DELEGATED DECISION TO DETERMINE PLANNING APPLICATIONS

Reference No:	2026/62/92141/W
Site Address:	33, Hadrian's Close, Salendine Nook, Huddersfield, HD3 3XZ
Description:	Demolition of existing conservatory and outbuilding and erection of two storey side and rear extension
Recommending Officer:	James Evans

Officer Report – 2026/92141

NO FOUNDATIONS OR ROOFS AND GUTTERS
ETC SHALL OVERSAIL THE BOUNDARY AND
ENCROACH ON ANY ADJOINING NEIGHBOURS
PROPERTY

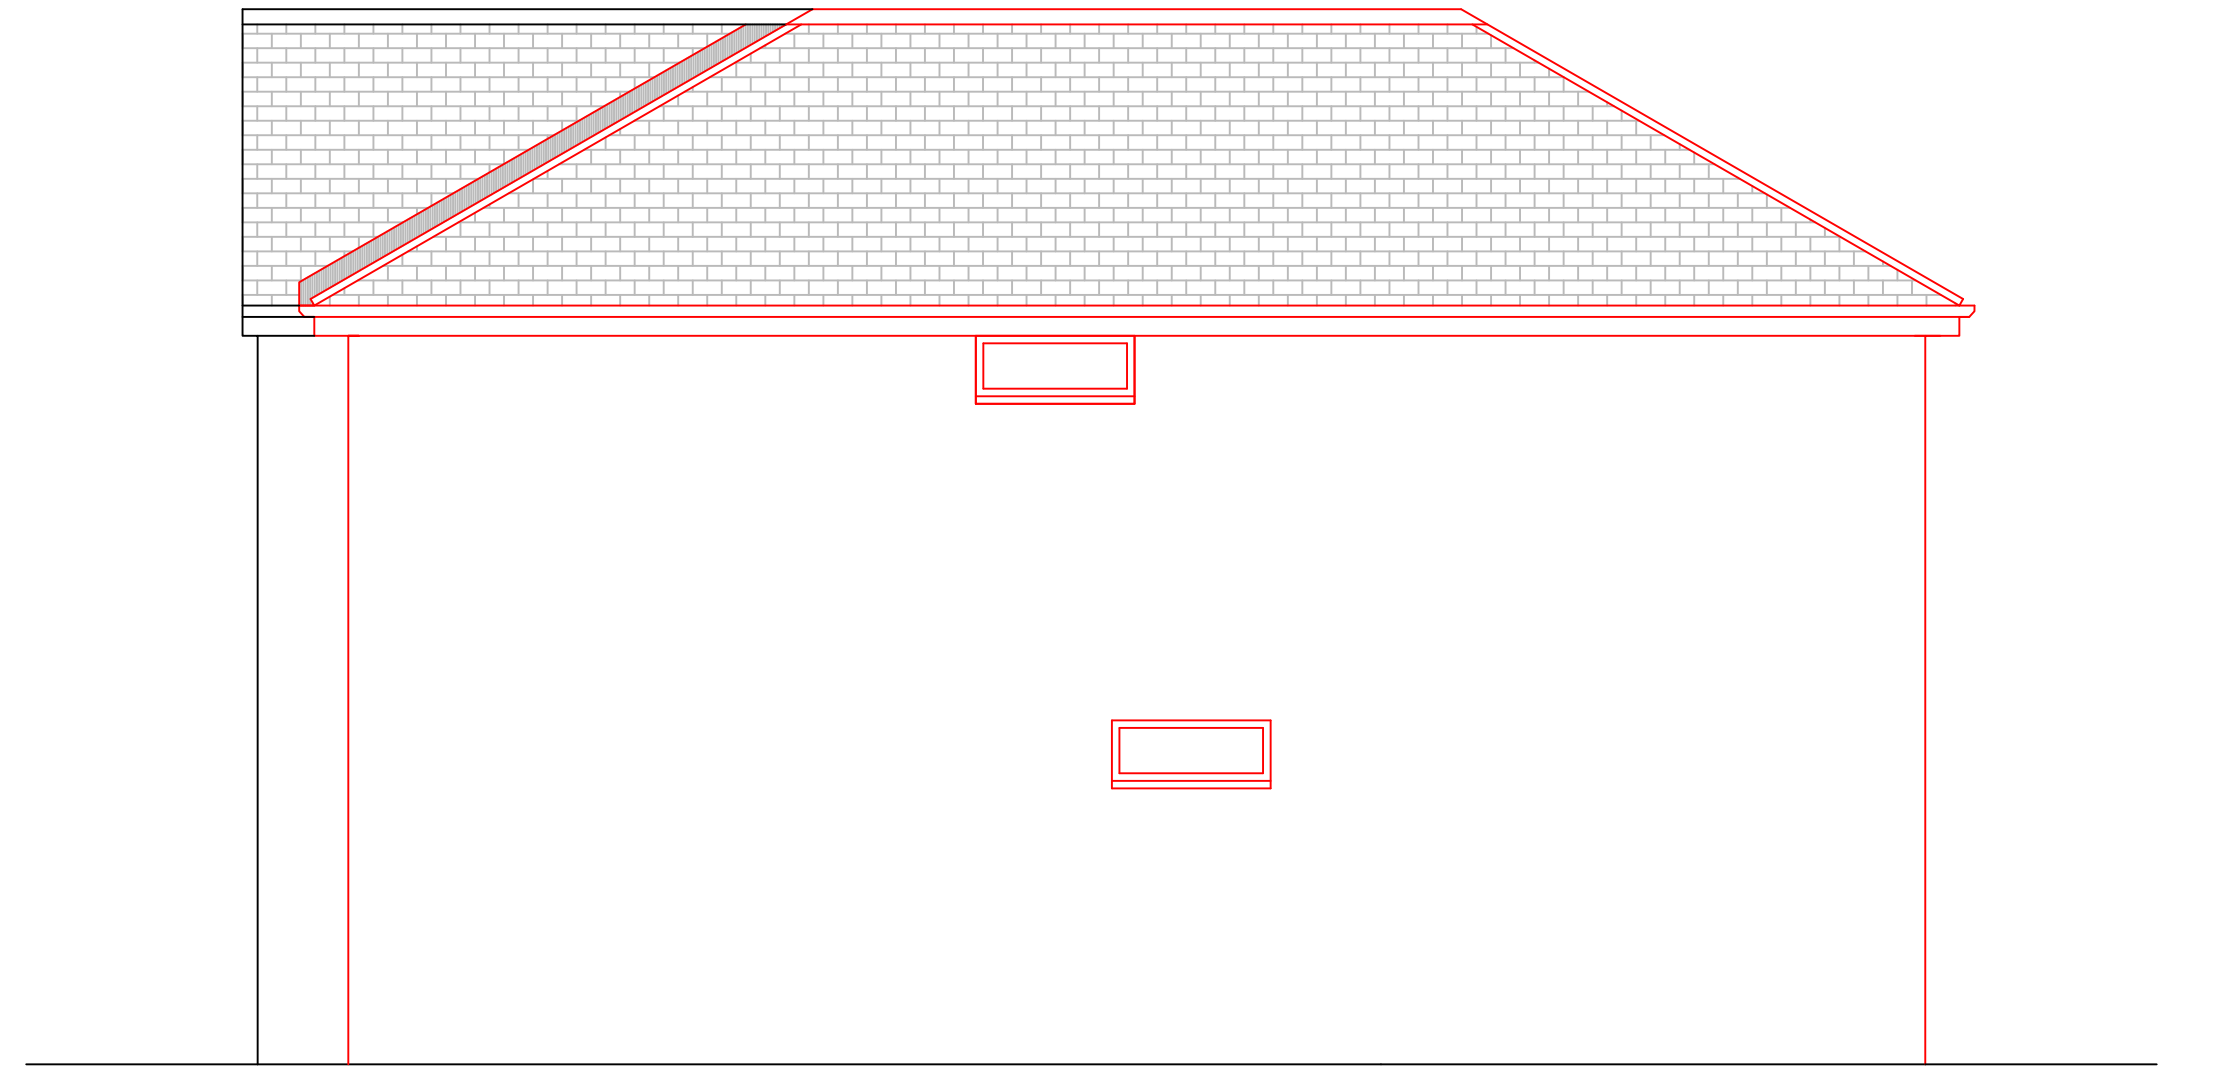
The two-storey side extension will be set back 0.7m from the front elevation of the host property, and will project 2.1m from the existing side extension. However, the side extension will decrease the gap to the shared boundary with 35 Hadrian's Close to 0.35m, in a departure from the SPD. This departure is considered acceptable on balance due to the previously approved proposal (2016/93097), which granted planning permission for a smaller gap to the boundary.

With regard to overlooking, there are two proposed openings in the north facing elevation of the extension, however these are high level windows that will have limited overlooking impact on 35 Hadrian's Close.

With regard to overshadowing, it is noted that the proposal is larger in scale than the previously approved application, importantly the proposed extension projects further along the shared boundary than the previous proposal. This may cause additional overshadowing in the early hours but it is noted that the area affected is mostly taken up by the existing outbuilding at 35 Hadrian's Close. Additionally, the proposal passes the 45 degree rule, so is considered acceptable in this regard. In terms of overbearing, it is considered that an acceptable degree of openness remains at 35 Hadrian's Close, particularly to the west and north.

The two-storey rear extension is the aspect of this proposal considered most relevant to 31 Hadrian's Close. There are no concerns regarding overlooking as there are no proposed openings in the south facing elevation of the proposed extension. It is acknowledged that the proposed would increase the built form of the host property when viewed from the rear of no.31, however the extension is located to the north and it is not considered that it would lead to a detrimental overshadowing impact to the occupiers of no.31. Any potential overbearing impact is mitigated by the considerable separation distance between the properties and the existing outbuilding at No.31.
